Planning application number: 2022 / 91730

Development: Demolition of former dairy/snooker centre/storage and erection of 9 light industrial units

Location: Land Adjacent, 60, Northgate, Cleckheaton, BD19 3NB

**PARAGON HIGHWAYS**  
PARAGON HIGHWAYS  
OFFICE 20/21 THE REAR WALLED GARDEN,  
THE NOSTELL ESTATE,  
WAKEFIELD WF4 1AB  
01924 291536 /  
MAIL@PARAGONHIGHWAYS.COM

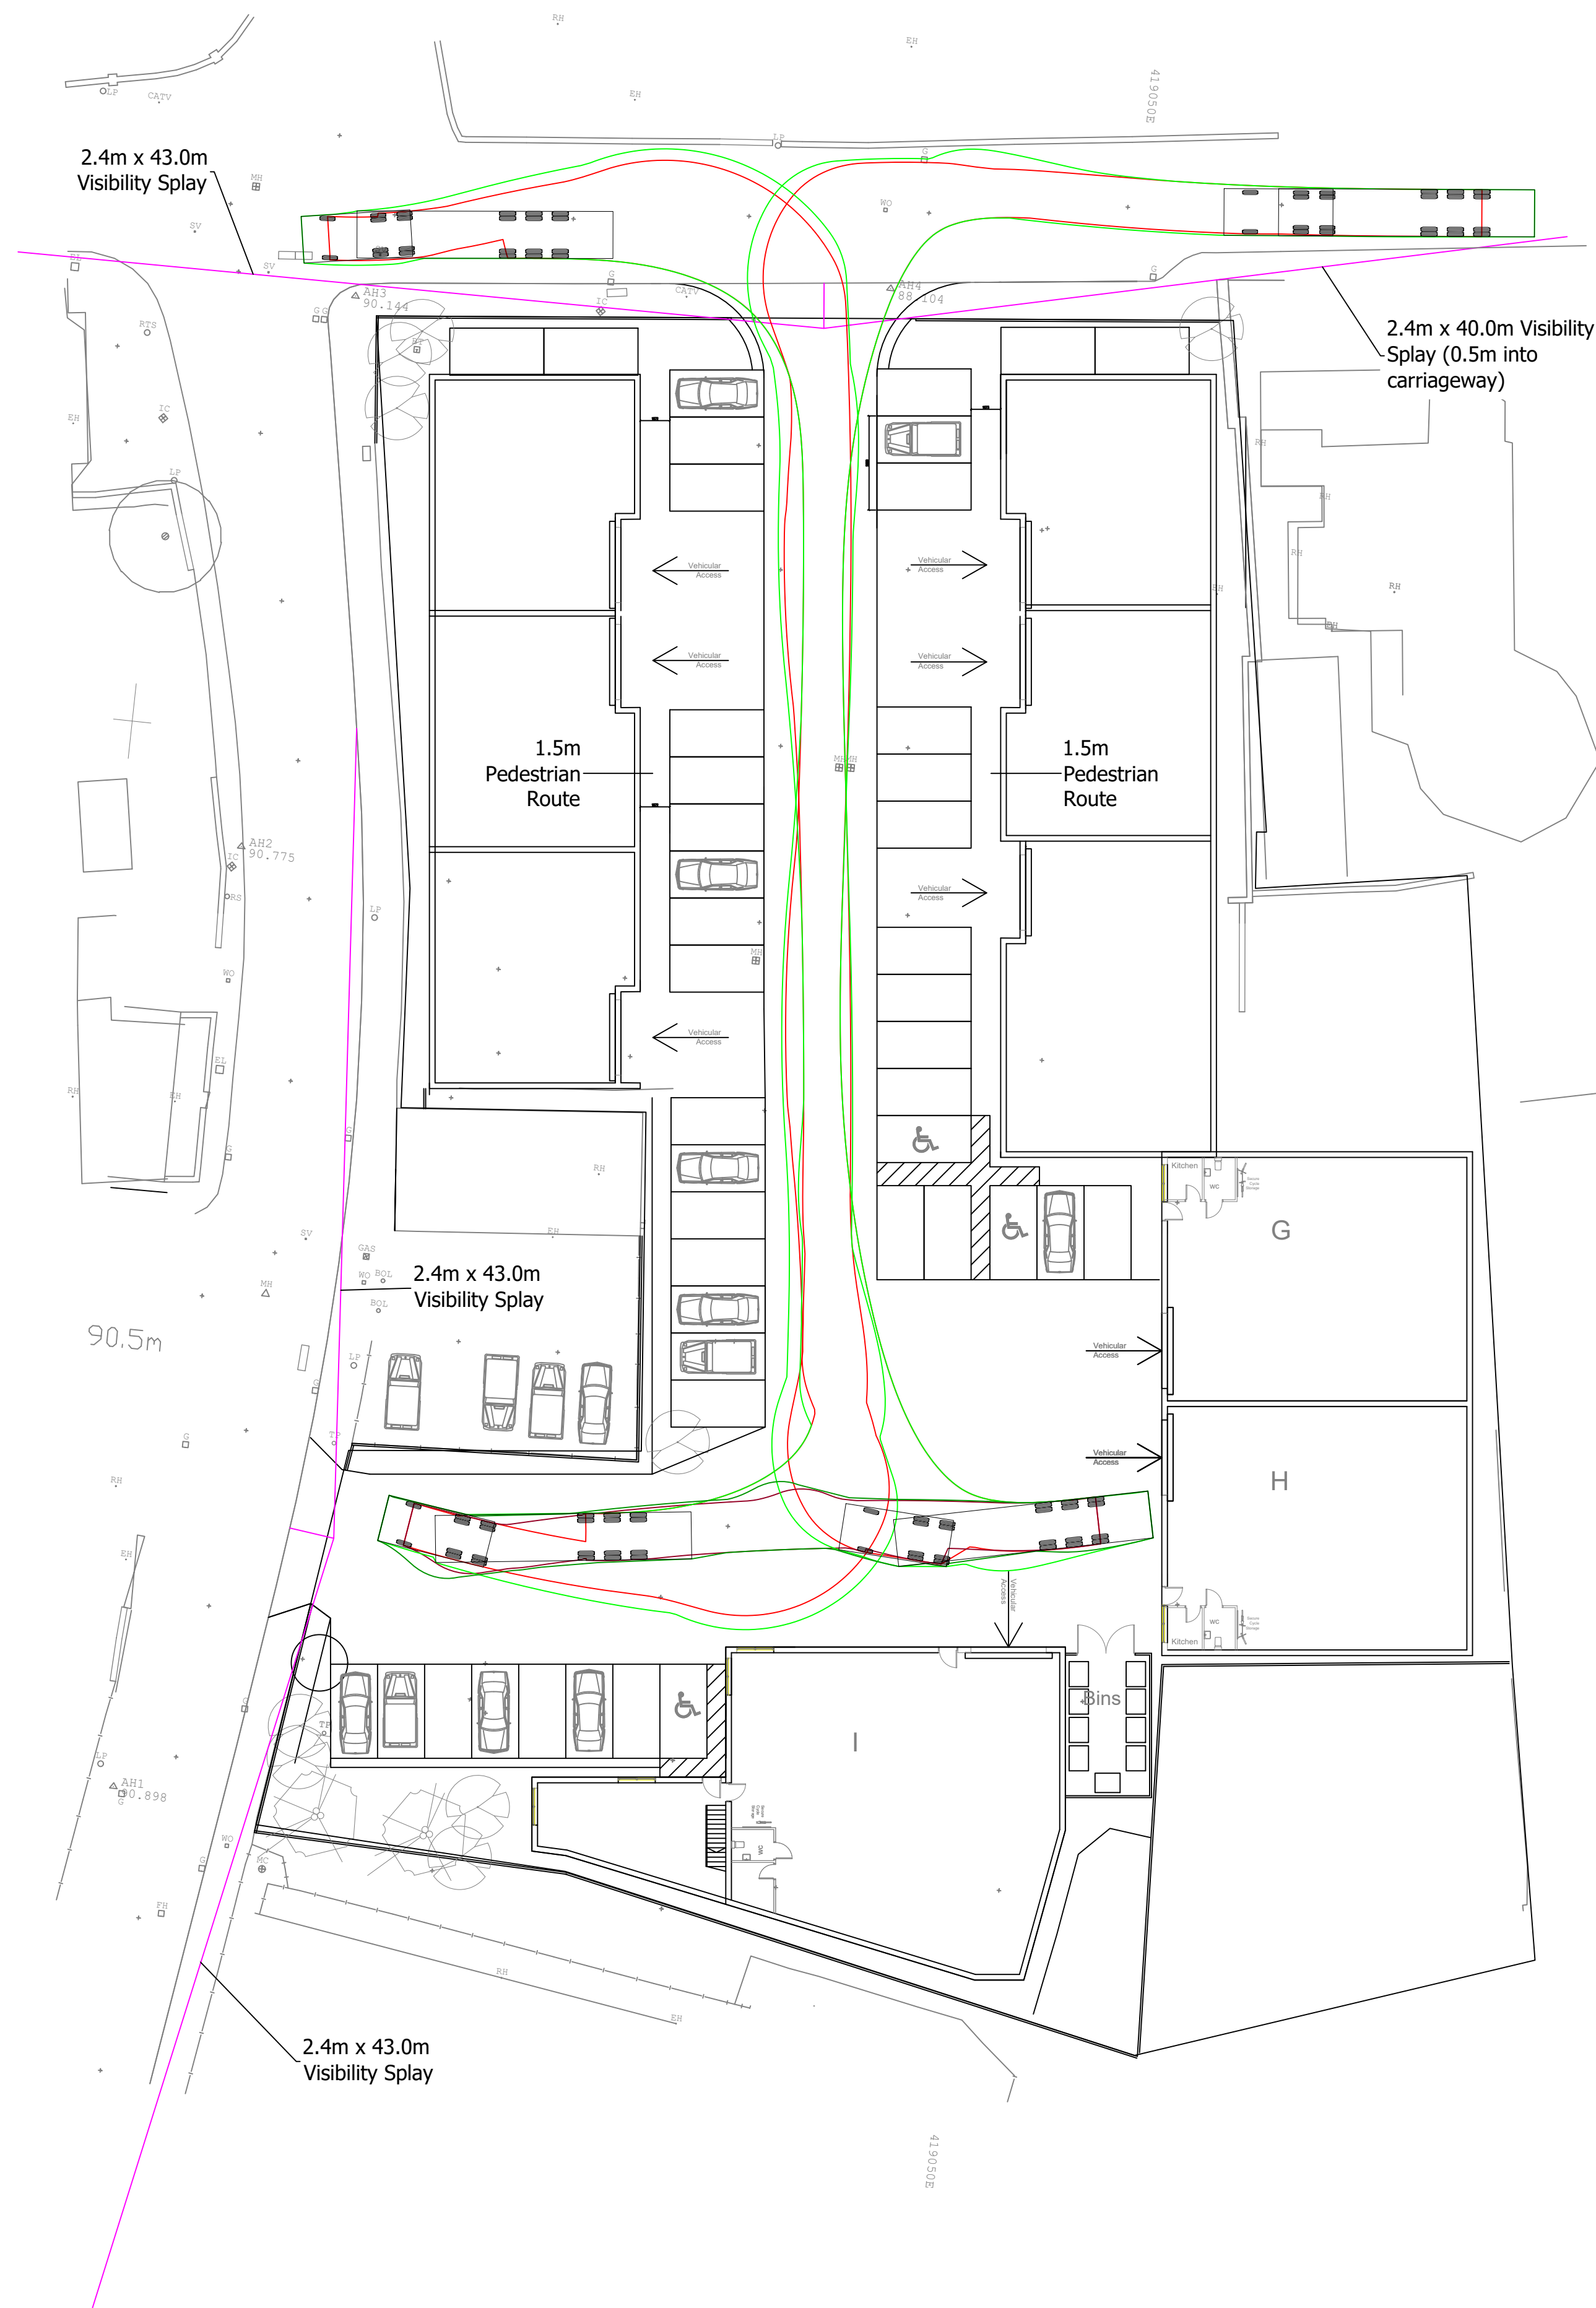
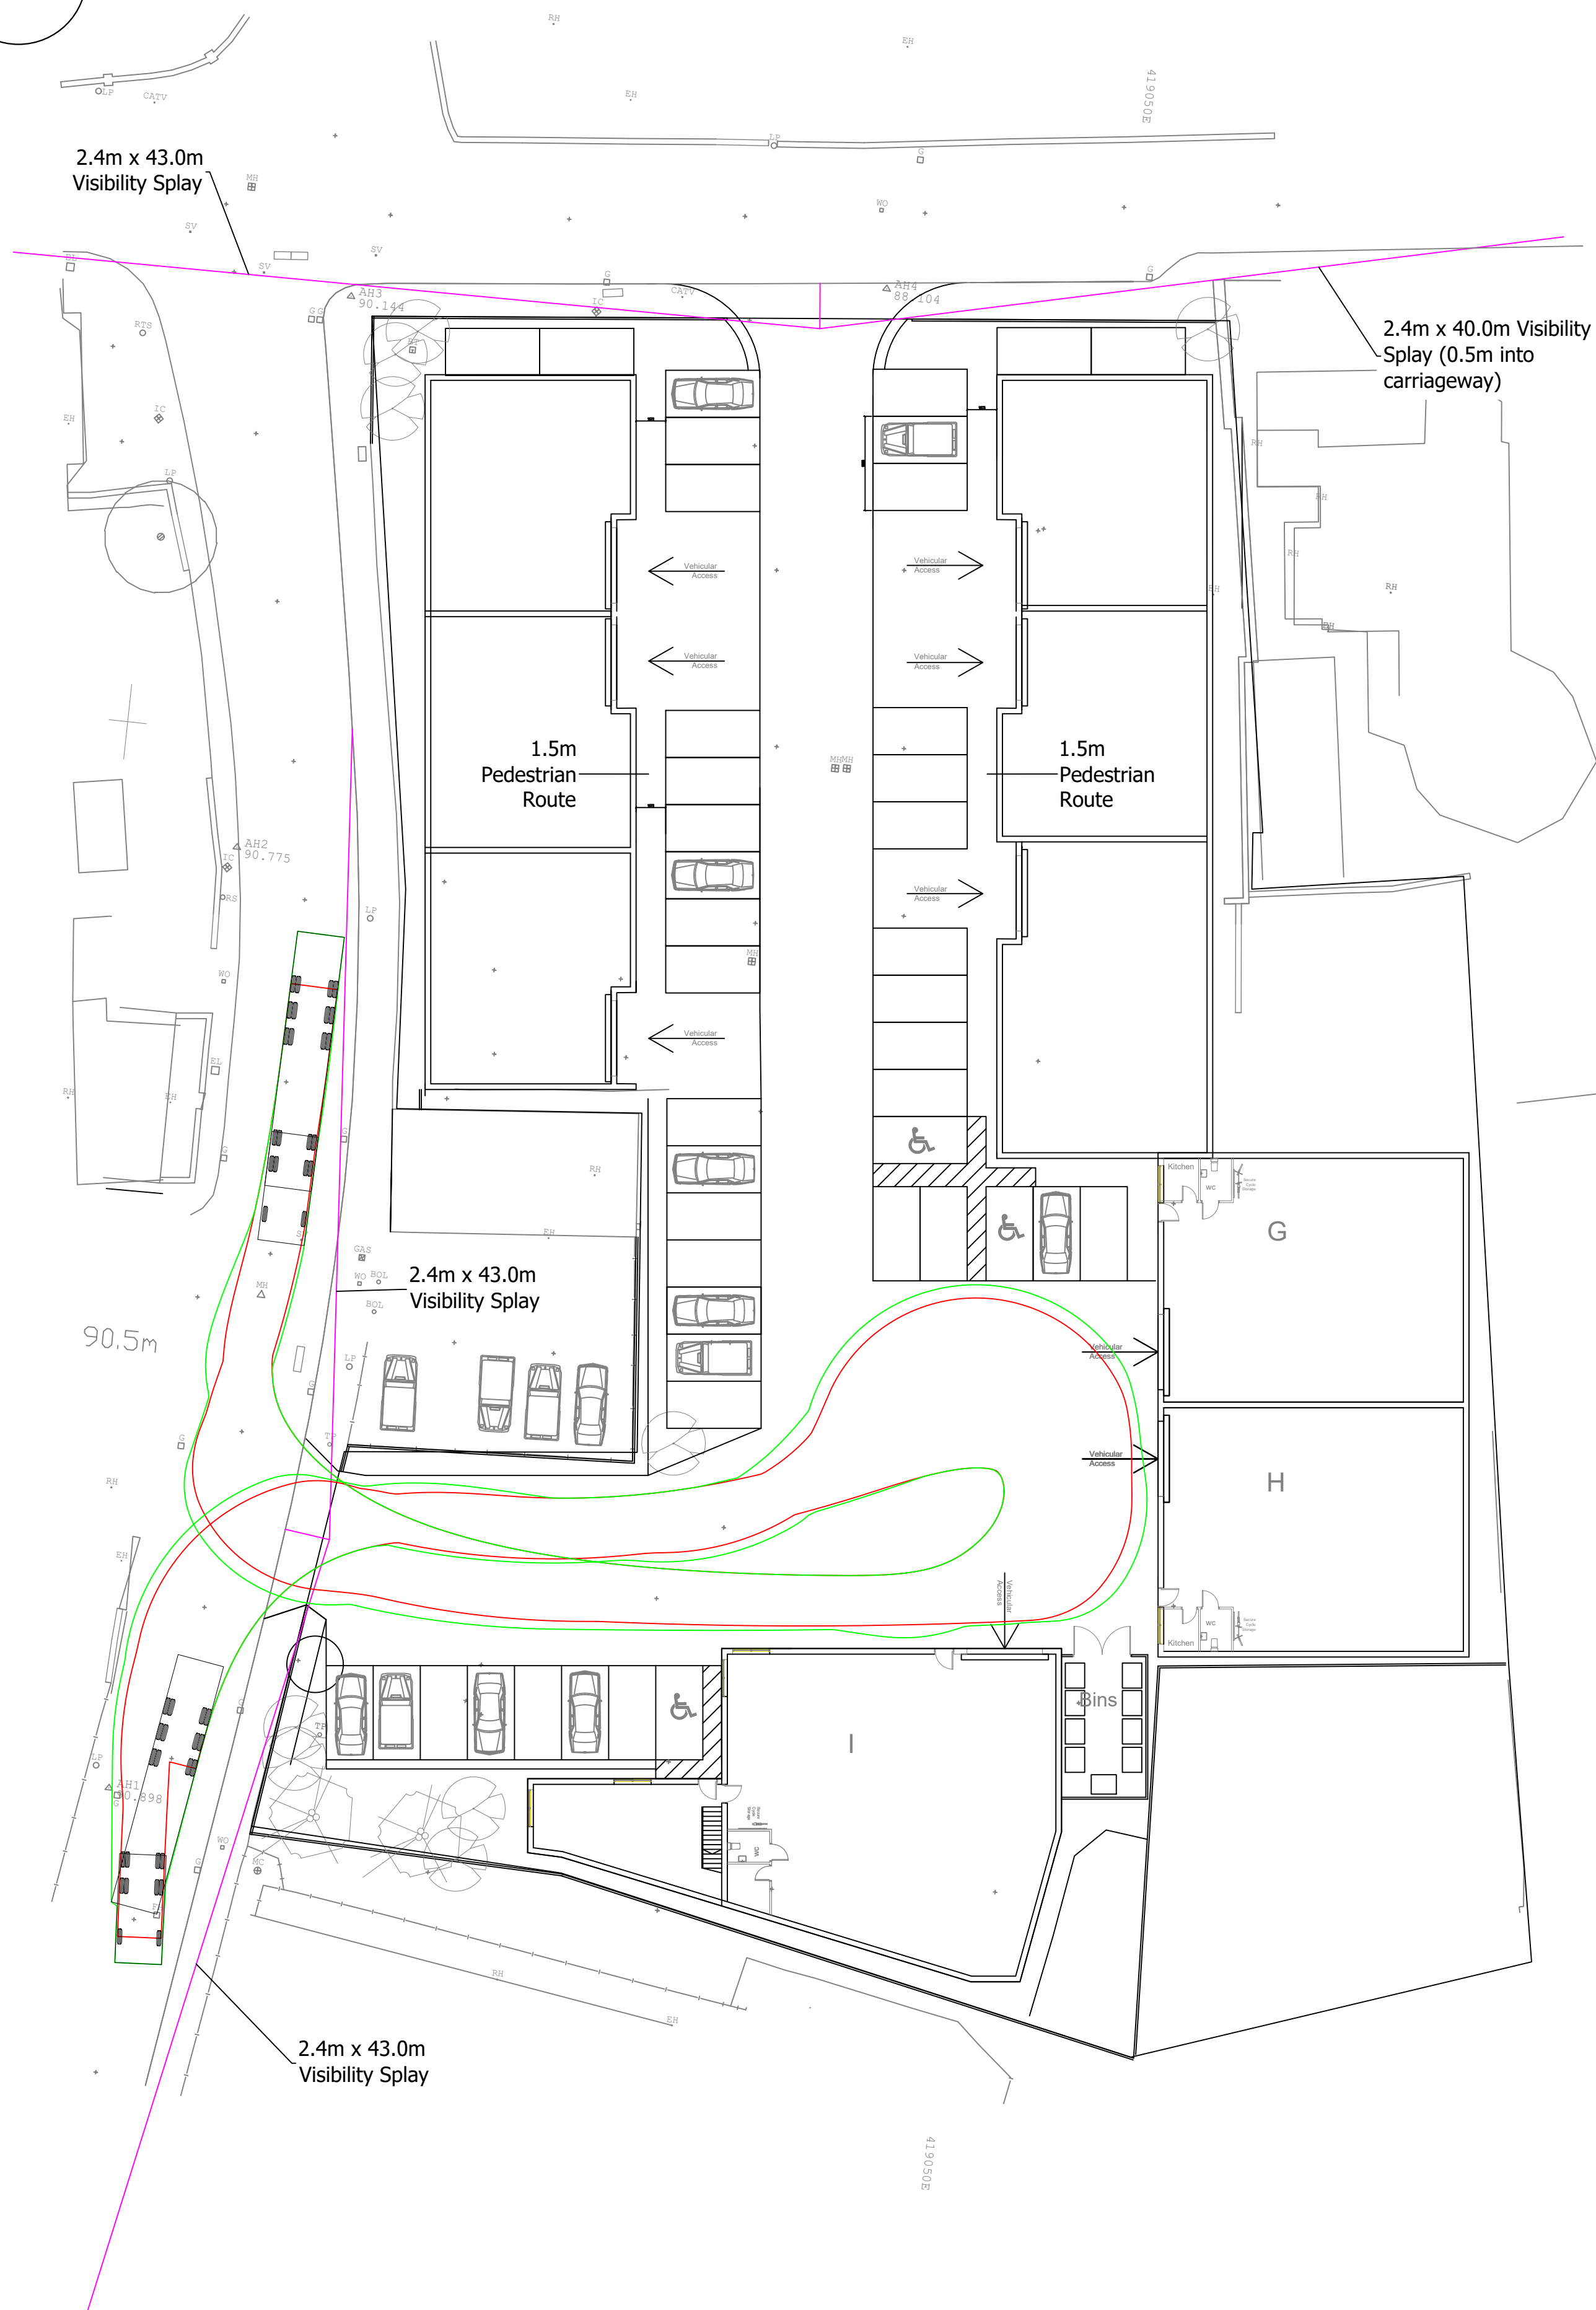
Given that KC Highways requires the applicant to track a 16.5m articulated lorry and provide appropriate kerb radii to both accesses (from Scott Lane and onto Northgate) which should be determined by 16.5m articulated lorry swept paths, the matter of the junction of Scott Lane with the main A638 Bradford Road is important and cannot be ignored.

In a tracking plan dating from November 2020 (document 846221 in the 2020/91747 application, & document 933314 in the present 2022/91730 application), Paragon Highways took a minimalist approach on behalf of the applicant, commencing its tracking of a 7.5T panel van from approximately halfway up Scott Lane, just metres from the site access, and ended its tracking within the site itself, with no tracking onto Northgate and beyond. Entering the site, even a 7.5T panel van crosses the centre white line to enter the site.

Earlier tracking illustrated at Appendix C of the Transport Assessment report of Paragon Highways dating from May 2020 similarly commences tracking just a few metres from the access points, and a vehicle illustrated exiting the site onto Northgate in the direction of its junction with Horncastle Street and Serpentine Road also crosses the centre white line into the path of oncoming traffic.
